SUBJECT: SFD2402-0046
SINGLE FAMILY DWELLING

Here are the results of all Inspections located at **691 KRAMER RD:**

site plan
Patrick J. and Alice A. O'Kelley
 plat book 2012 page 88-89
 Barbecue Township
 Harnett County N.C.
 Scale 1" = 100' Feb. 13, 2024

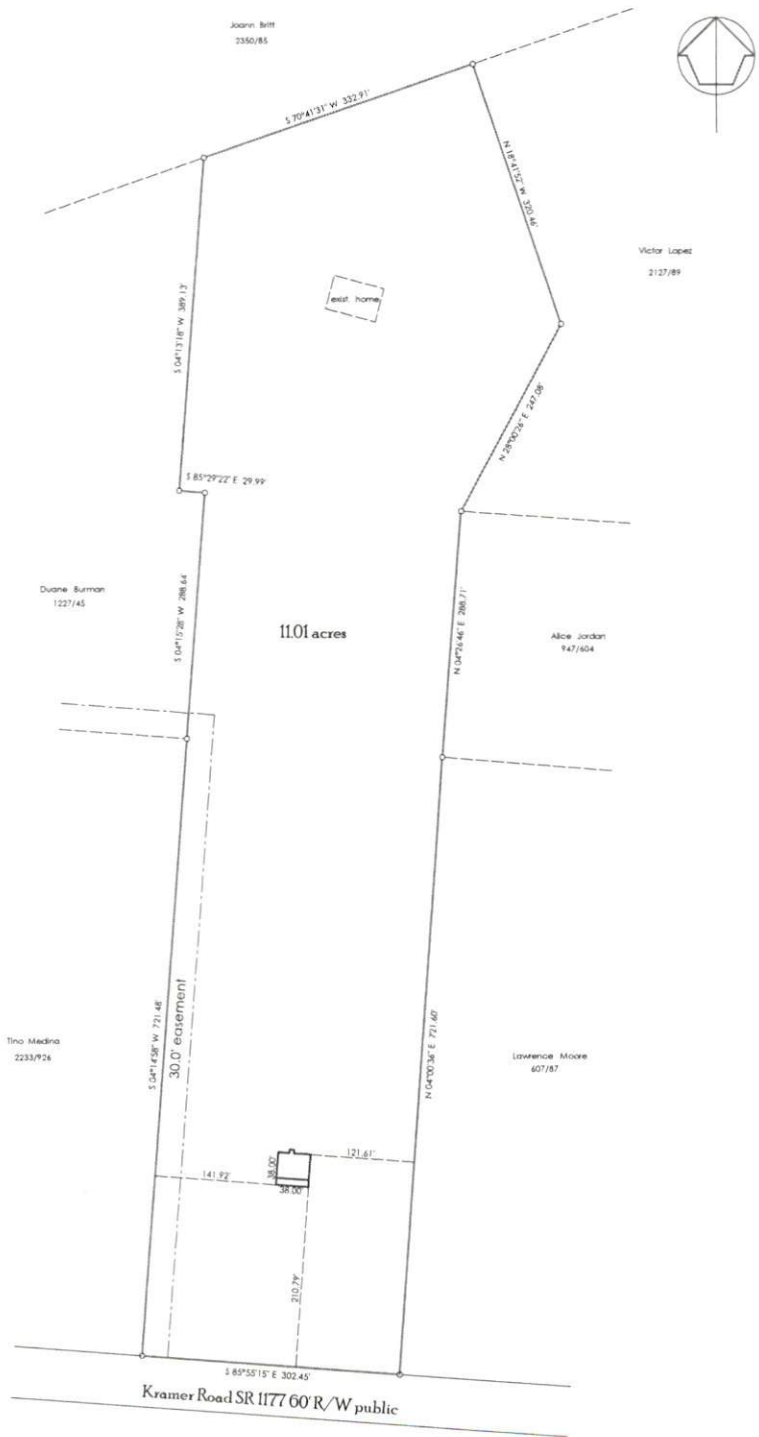
Inspection Type: ADDRESS
Scheduled Date/Time: 2/13/2024
Completed Date/Time: 2/15/2024
Inspector: GIS Bucket
Result: DISAPPROVED
Remarks:
Notes: 2nd home on lot

Will this have it's own individual driveway or will it use the same driveway access off Kramer Rd as 709?

SITE PLAN SHOWS 2ND DRIVEWAY. 691 KRAMER RD LILLINGTON 27546. POS ADDRESS SIGN AT ROAD.
